Dear Sir, I am writing to you in connection with the proposed change of use from premises in light industrial use to dwelling 'houses' at 66 The Street, Rustington. R/205/19/PD.

Drawing No P01

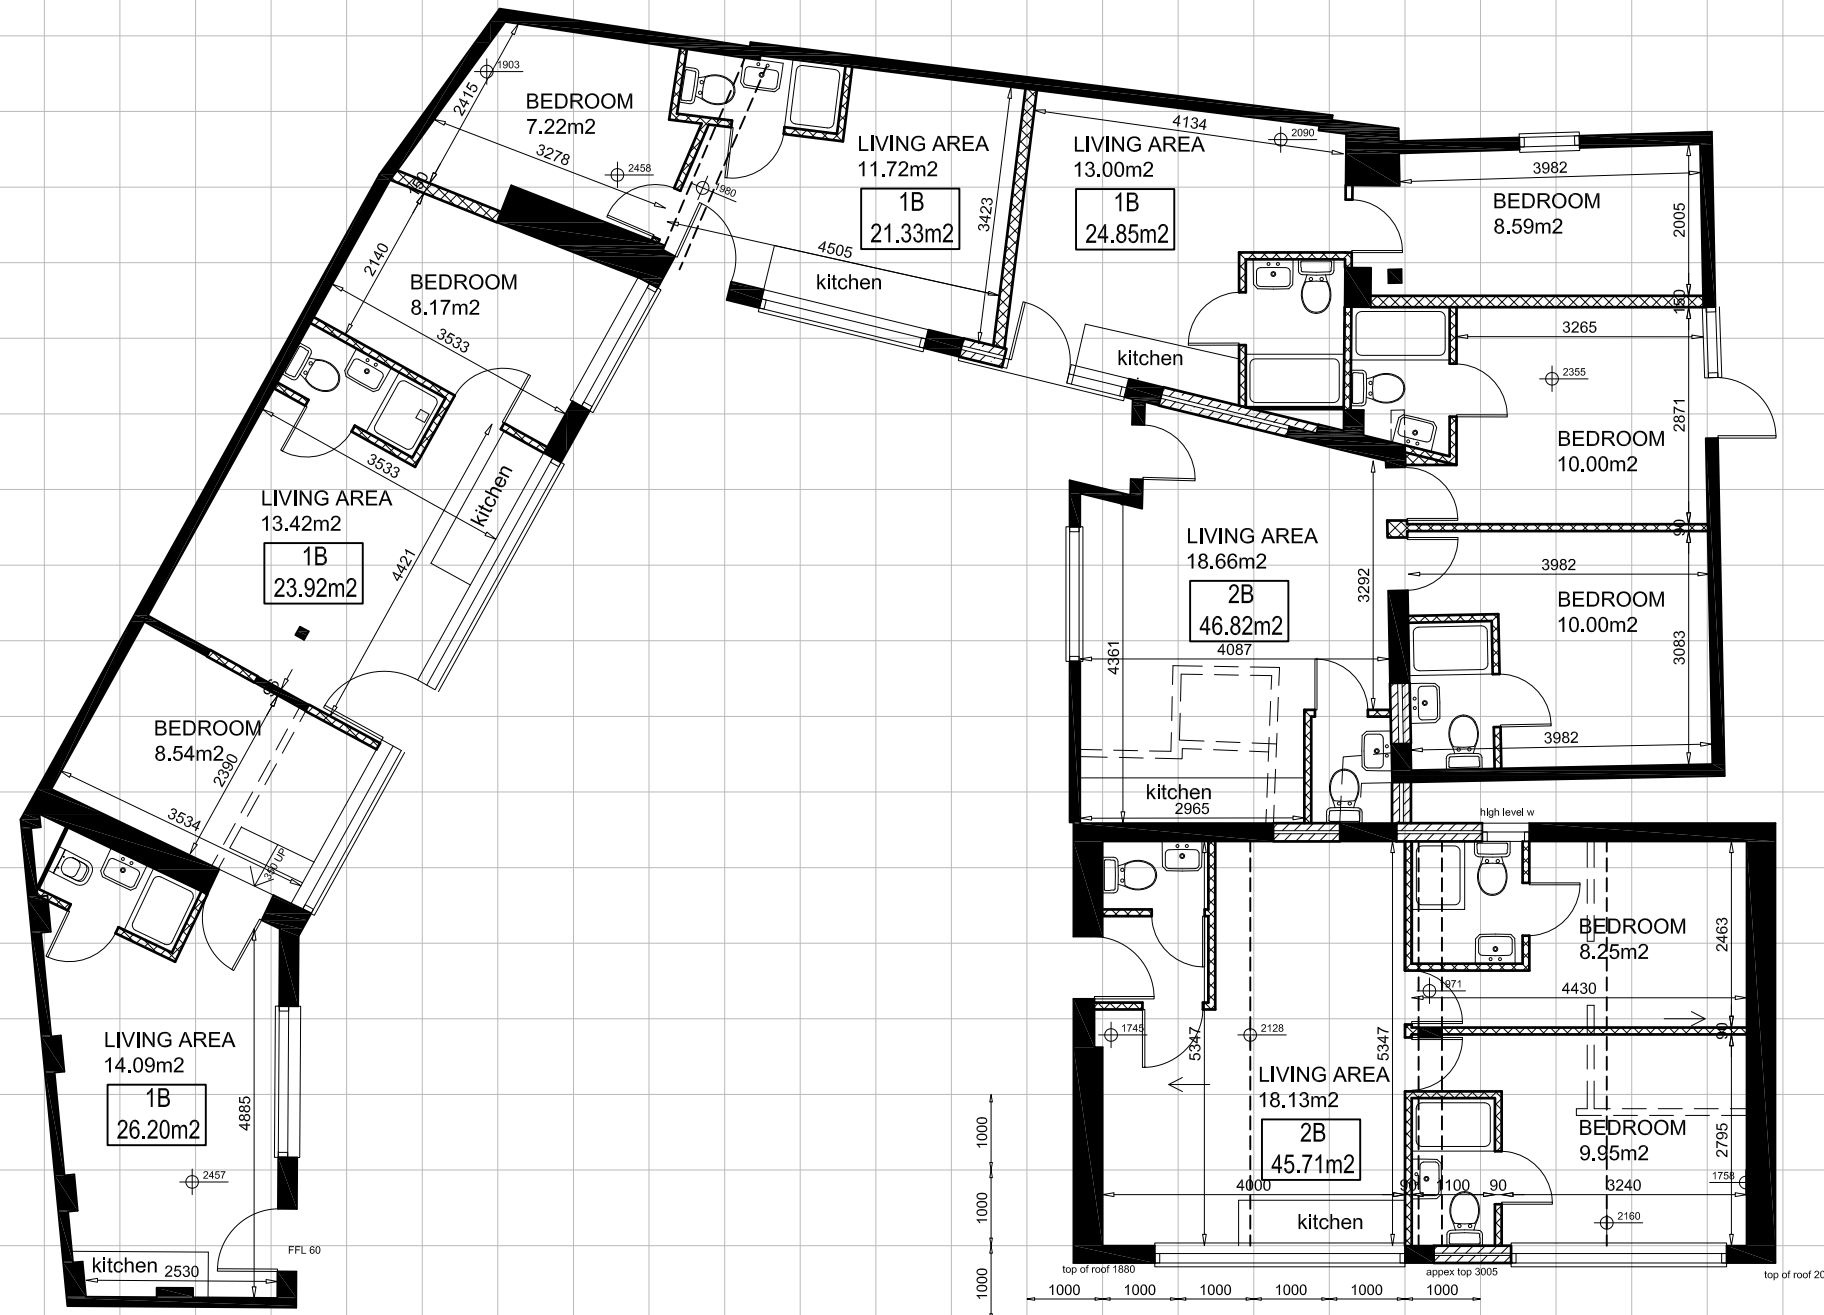
Looking at the design, the one bedroom 'units' (they can't be called flats) are so small and so ill designed that I cannot think who on earth would buy them They each range in size from 28.55sq m to 34.72sq m., have no hallway, the bathroom is built in a corner of the living room and the kitchen along another wall in the living room, from which the bedroom is accessed. Two rooms in total and the view out of their window is of the industrial bins and pipework at the rear of the shops. The Two bedroom flats are little better - 63.51sq m & 66.82sqm . All units appear to have only one exit doorway, and, from a quick look, the area in the centre is only about 25ft from front door to front door a disaster waiting to happen.
